Application for a non-material amendment following a grant of planning permission.

Construction of 16 dwellings, comprising 4no. 3bedroom townhouses, 3no. 4 bedroom accessible houses and 9no. 2 bedroom flats with associated parking (resubmission of 19/01690/CS3)

Reference number:	<input type="text" value="20/00357/CS3"/>
Date of decision	<input type="text" value="20/08/2020"/>

The provision of additional photovoltaic panels on the roofs of the apartments and houses.

Project DOYLE AVENUE, PORTSMOUTH
Title Proposed Flats
Dwg No 19.094.202
Status FOR PLANNING
Date SEPTEMBER 2019
Drawn By/Checked By IS/CK
Scale 1:100@A1
Revision D

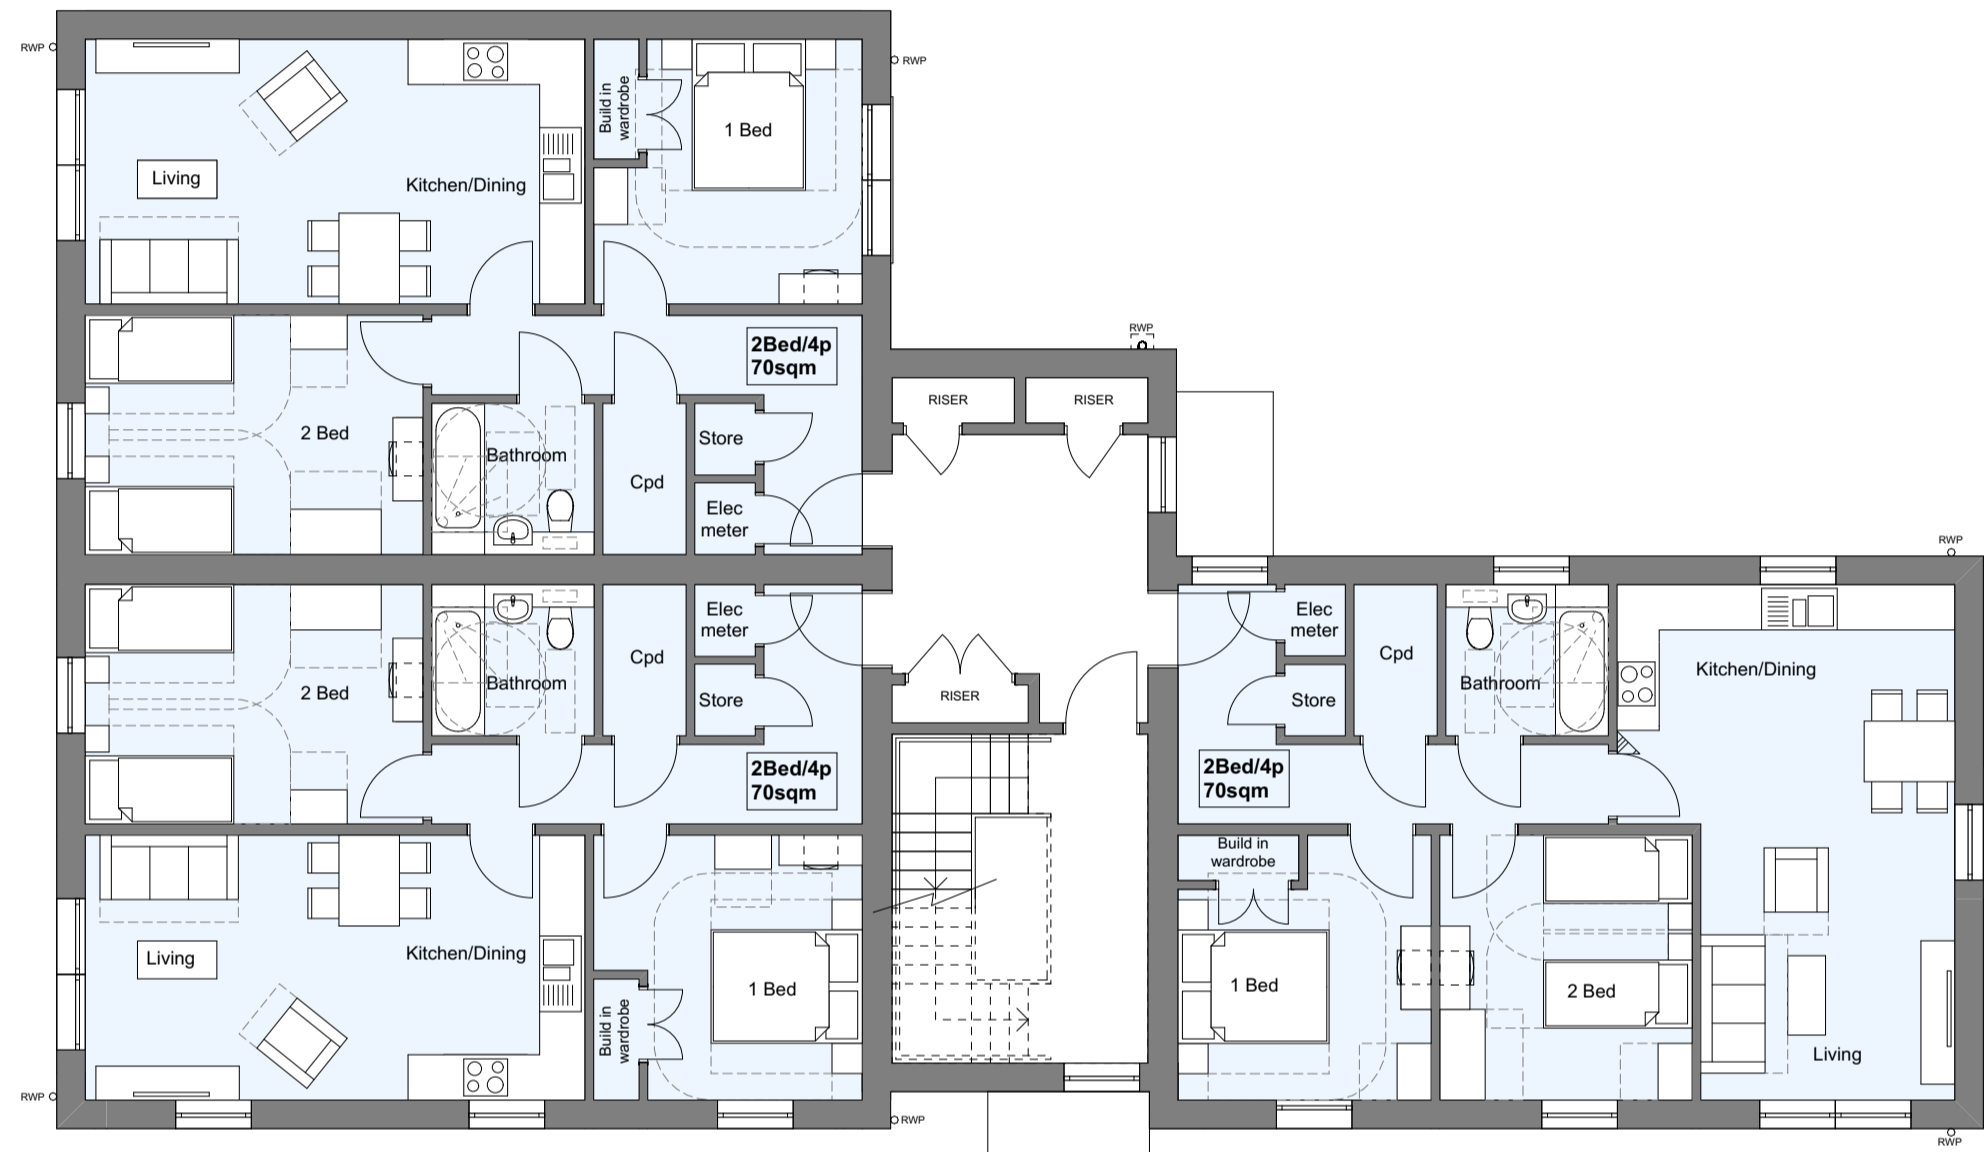
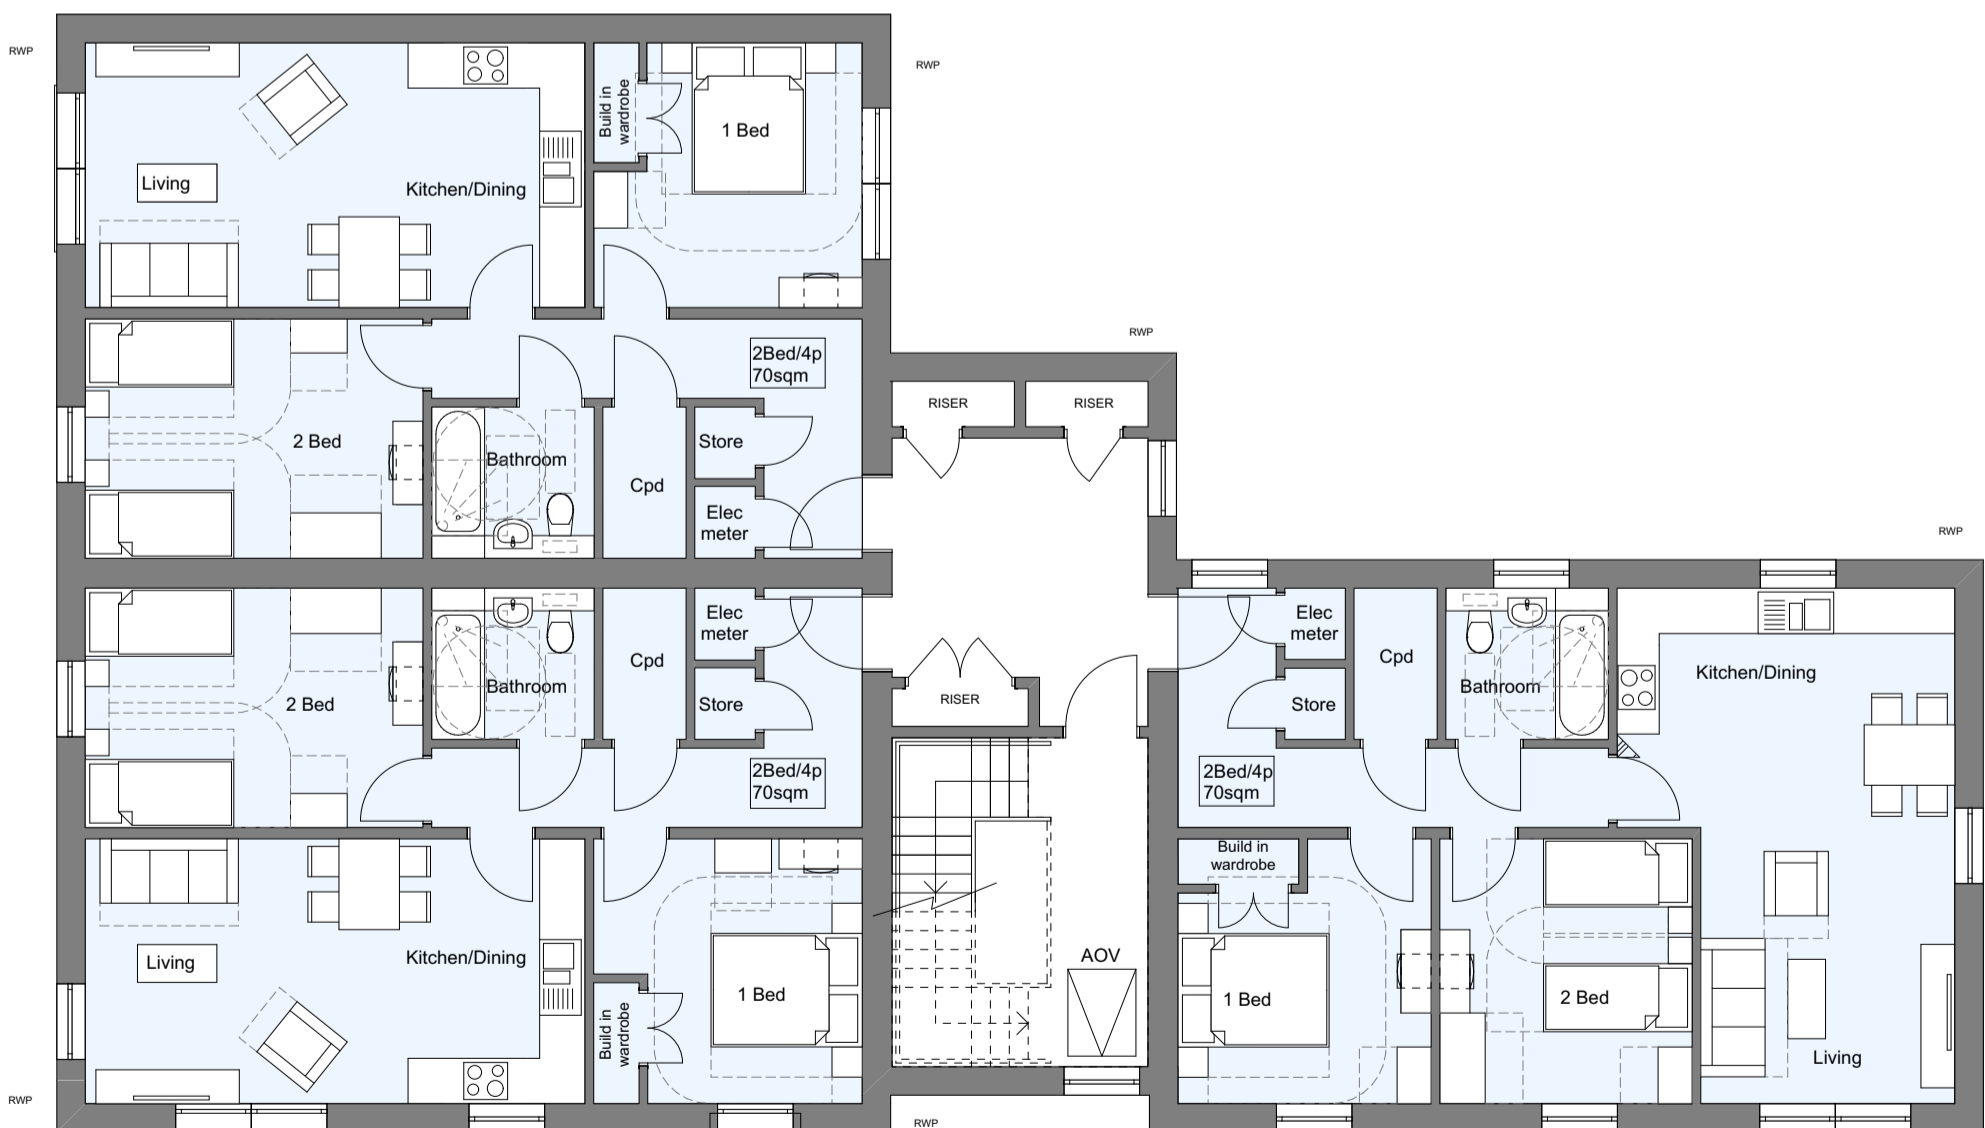
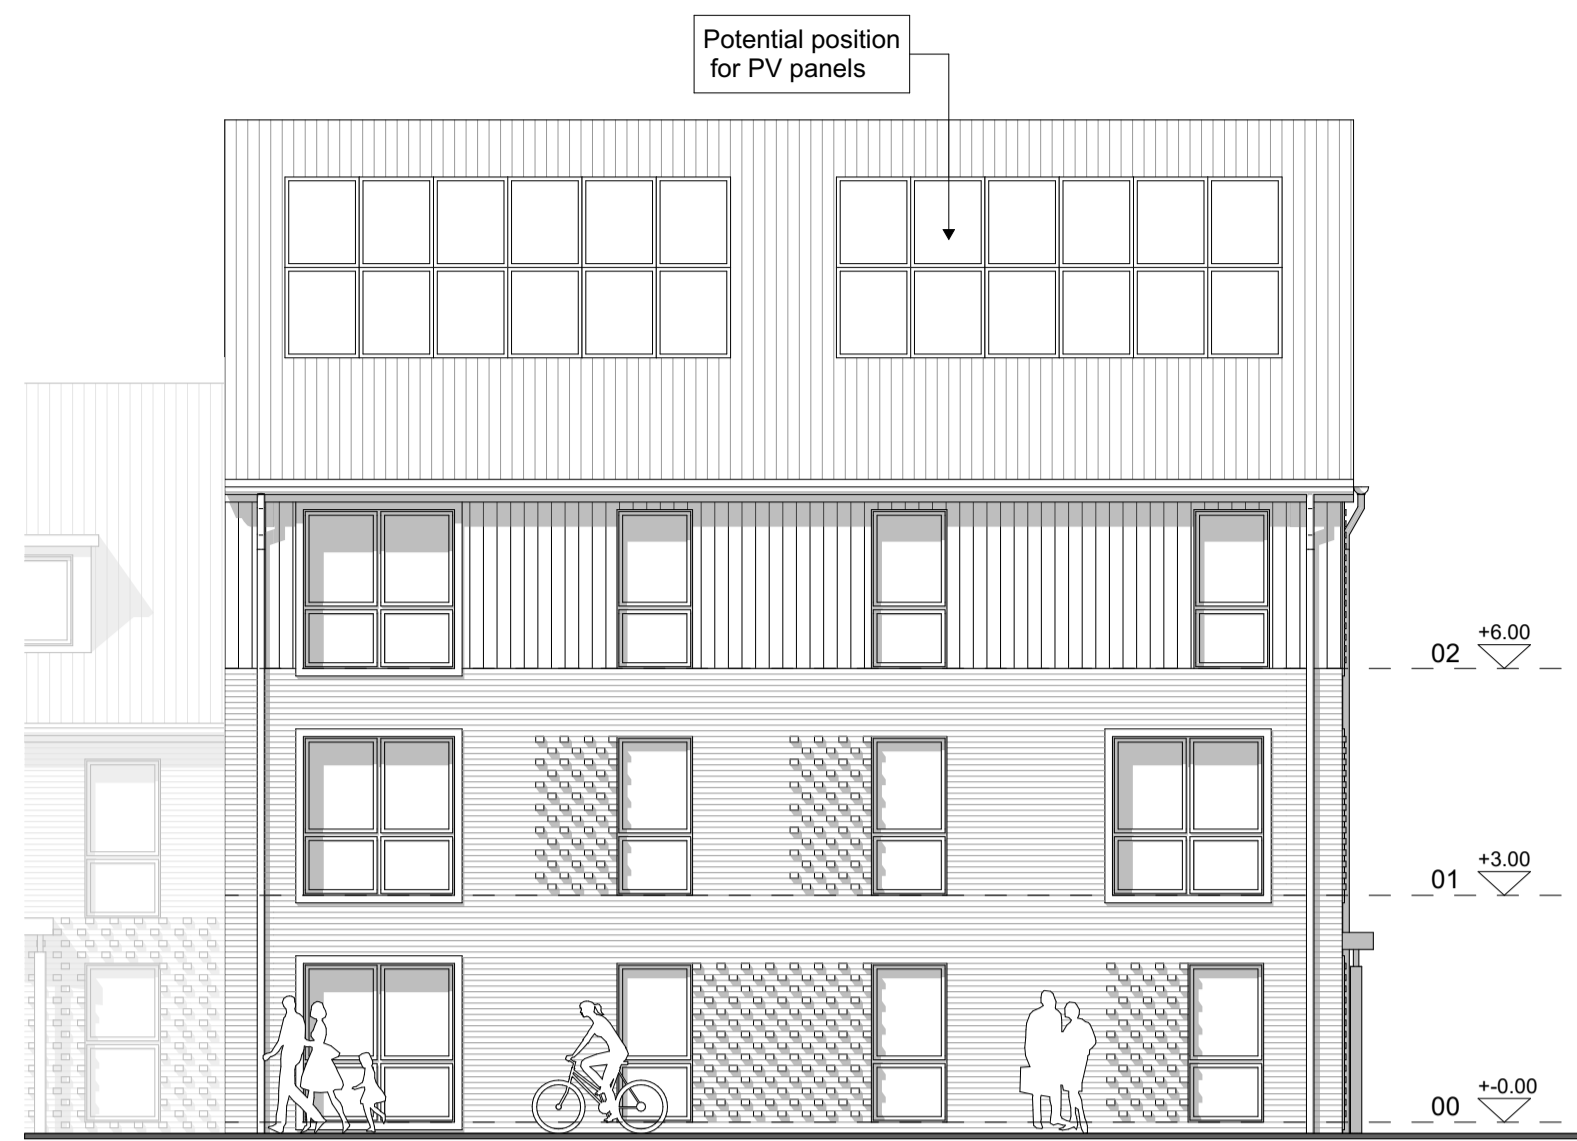
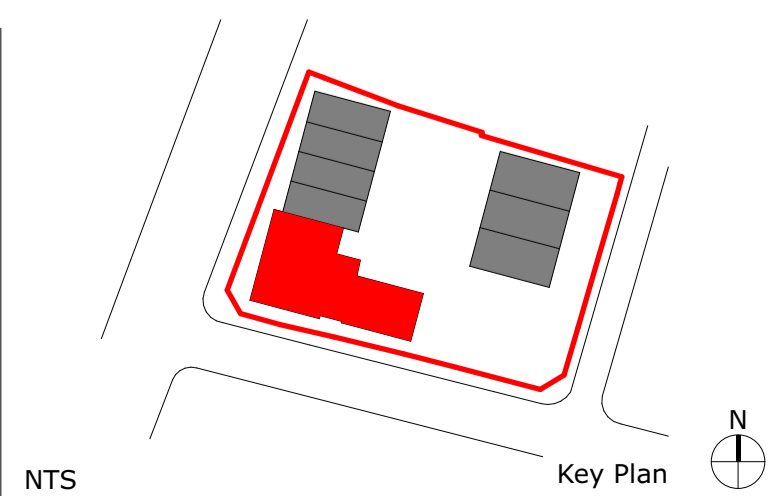
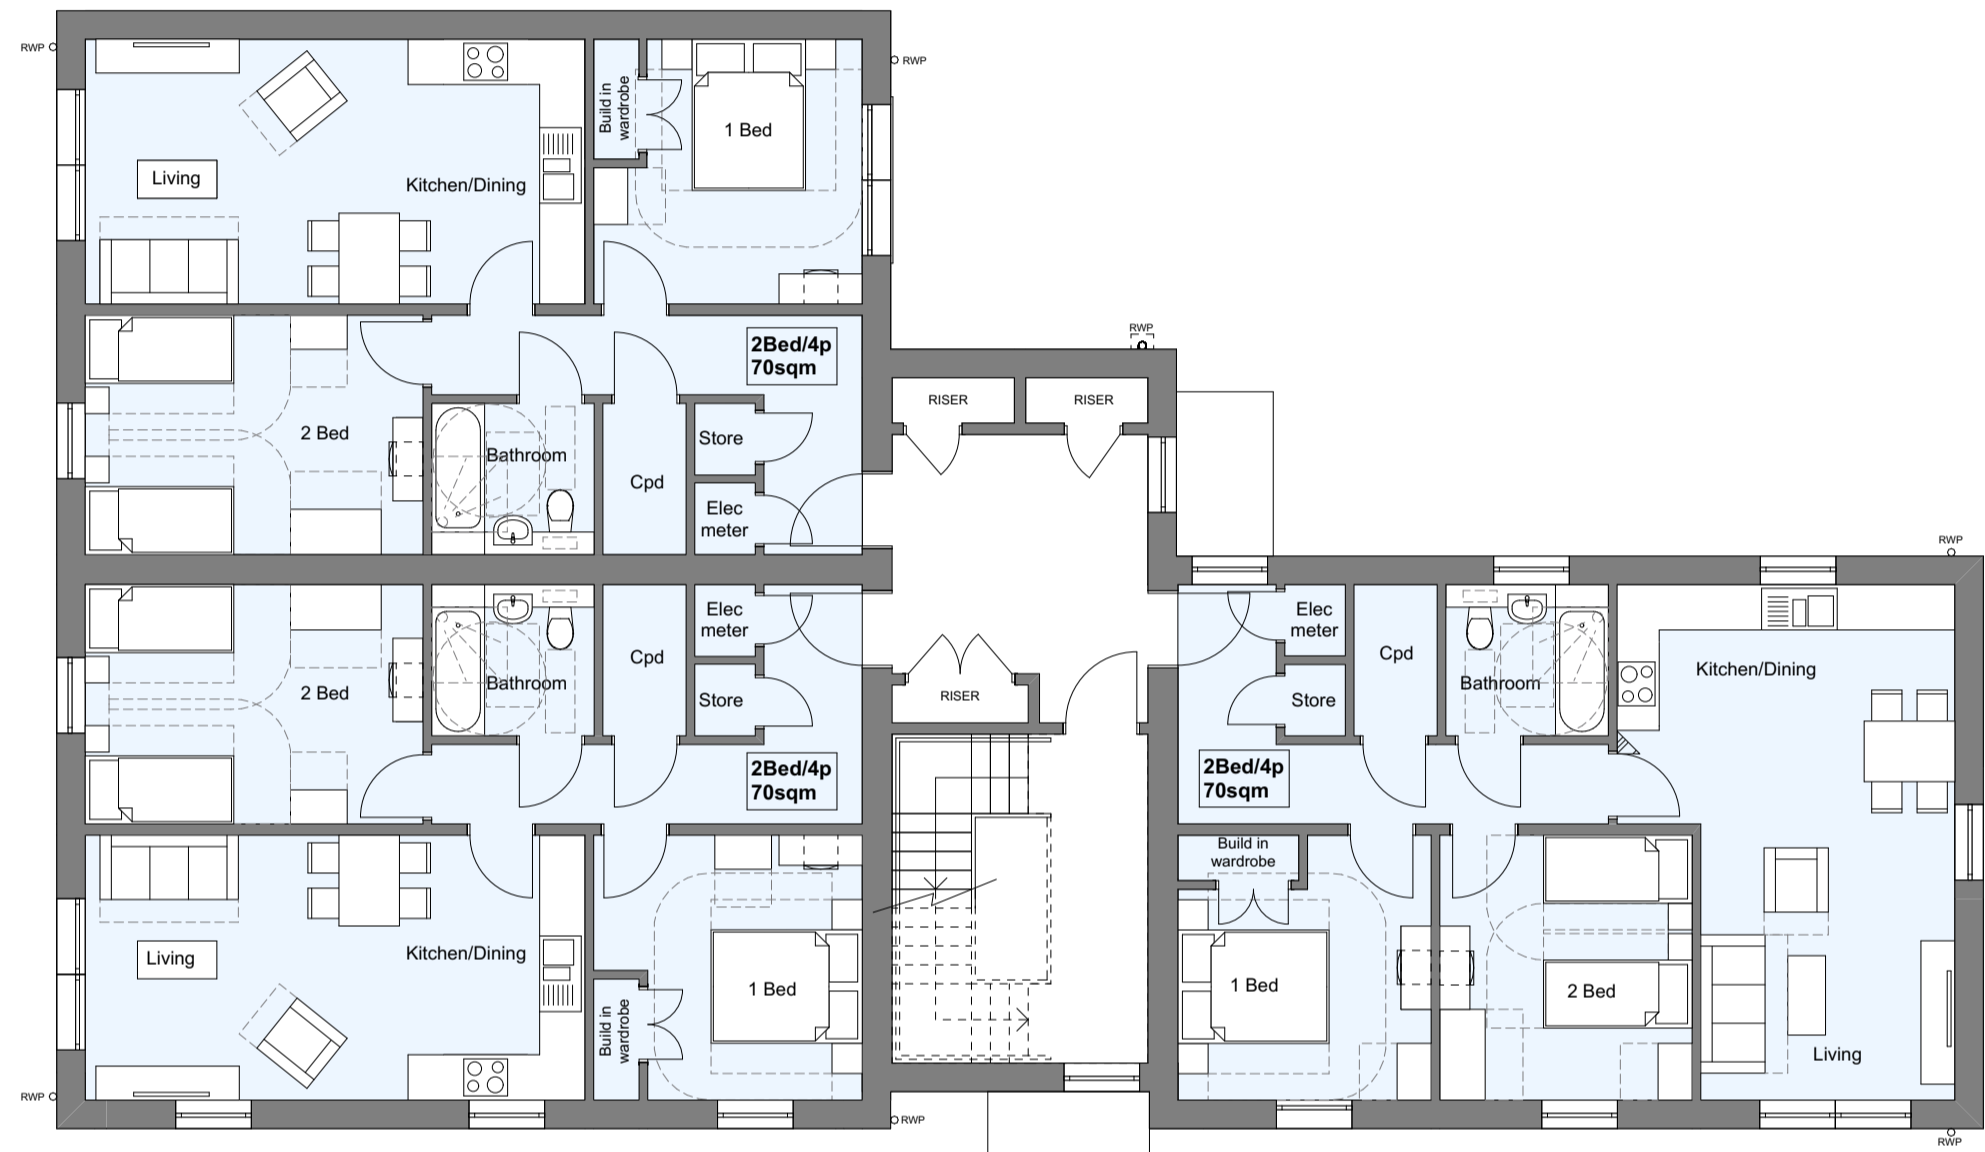
19.094.100 Rev E Proposed Site Plan (Roof Plan)  
19.094.202 Rev C Proposed Flats  
19.094.205 Rev C Street Scenes

19.094.100 Rev F Proposed Site Plan (Roof Plan)  
19.094.202 Rev D Proposed Flats  
19.094.205 Rev D Street Scenes

The amendment is being sought to improve the environmental performance, the efficiency and affordability of the units for the residents.
